Date: 13th April 2018

APPLICATION CONSULTATION RESPONSE

Application Number:	3/2017/1020
Location:	Unit A to C Up Brooks, Clitheroe, BB7 9SE
Grid Ref:	E 375182, N 442128
Proposal:	Proposed new production unit

CLUTTERIDGE LIGHT
ENGINEERING CO LTD
UPPERCROFT INDUSTRIAL ESTATE
PROPOSED NEW BUILDING
PROPOSED SITE PLAN
PHASE 2/200 OCTOBER 2017
1:100 at A1
10/3/16 ucl

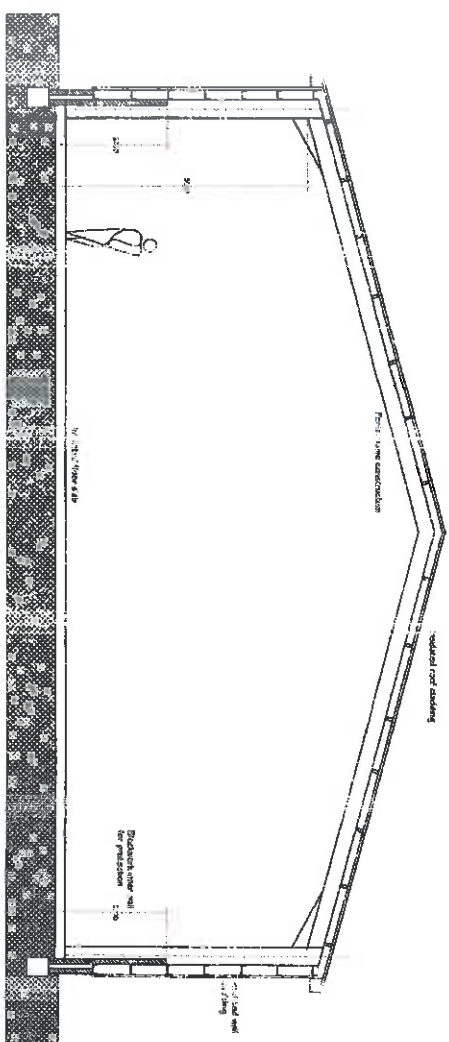
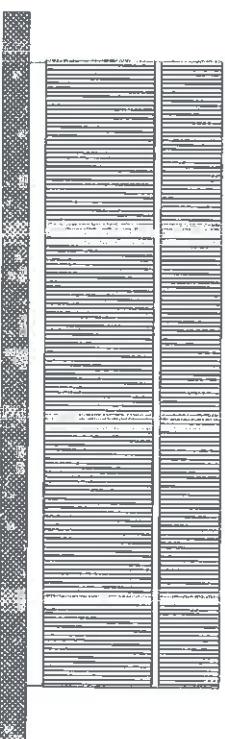
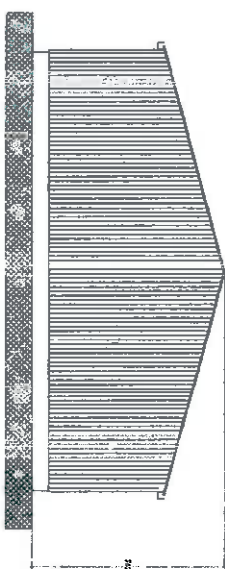
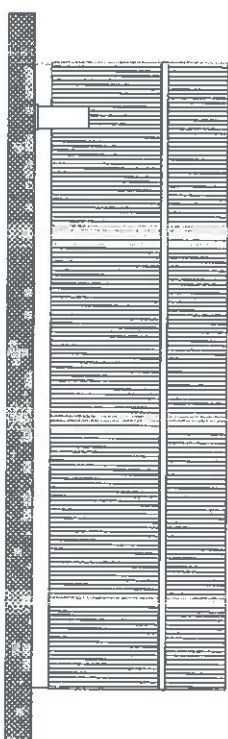
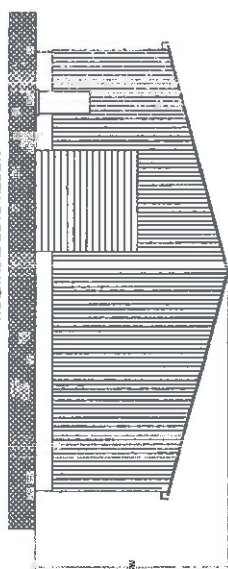
- Proposed site plan showing exceedance routes and building slab level

- Details of inlets, outlets and flow controls
- Long and cross section drawings of proposed drainage system(s), including design levels
- Details of appropriate water quality treatments

3. Detailed drainage drawings including plan showing exceedance routes.
4. Sustainable drainage system flow calculations.
5. Attenuation volume calculations.
